Previous comments not addressed:

At minimum, special use site plan shall include the following elements. If any are not applicable to this project, please indicate so:

CUSTOMER: HARPER, BARRY  
ADDRESS: 13645 GYM KHANA RD,  
LEGAL: LOT 10, CORRAL RANCHES, SUBDIVISION  
TAX ID: 4329001016  
ACRES: 8.33  
SCHOOL DIST: 49, FALCON

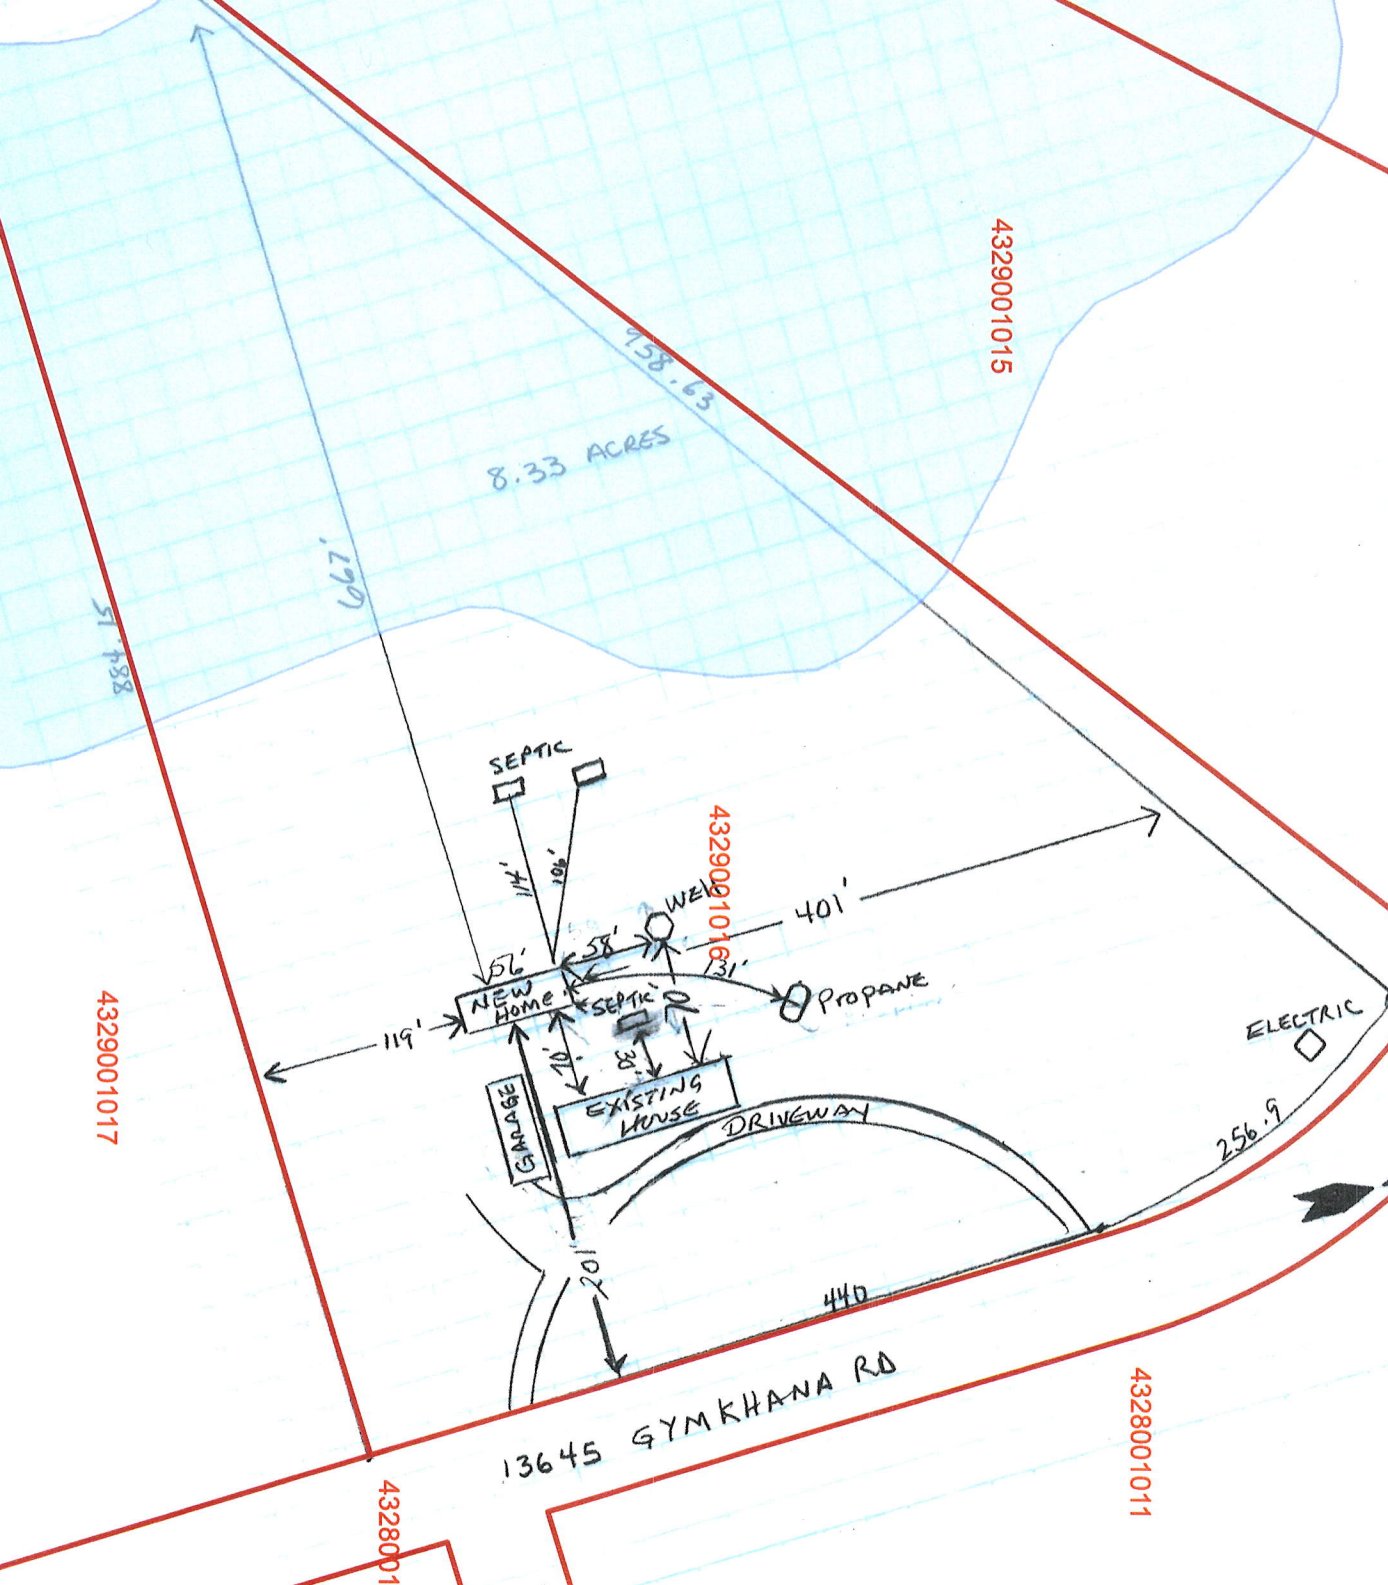
1. Existing land uses and zoning on the property and within 500 feet of the boundary.
2. Adjoining property ownership.
3. Existing easements.
4. Name and addresses of the petitioner, owners of all interests (including mineral interests), in the property, and preparer.
5. Location, height, and dimensions of each existing and proposed structure within the development and the uses to be contained therein.
6. Stages, if applicable, in which the project will be developed.
7. Location of all proposed uses, structures, and other natural or man made features and relationship of uses, structures, and features to internal and adjoining uses, structures, features, landscaping and transportation facilities.
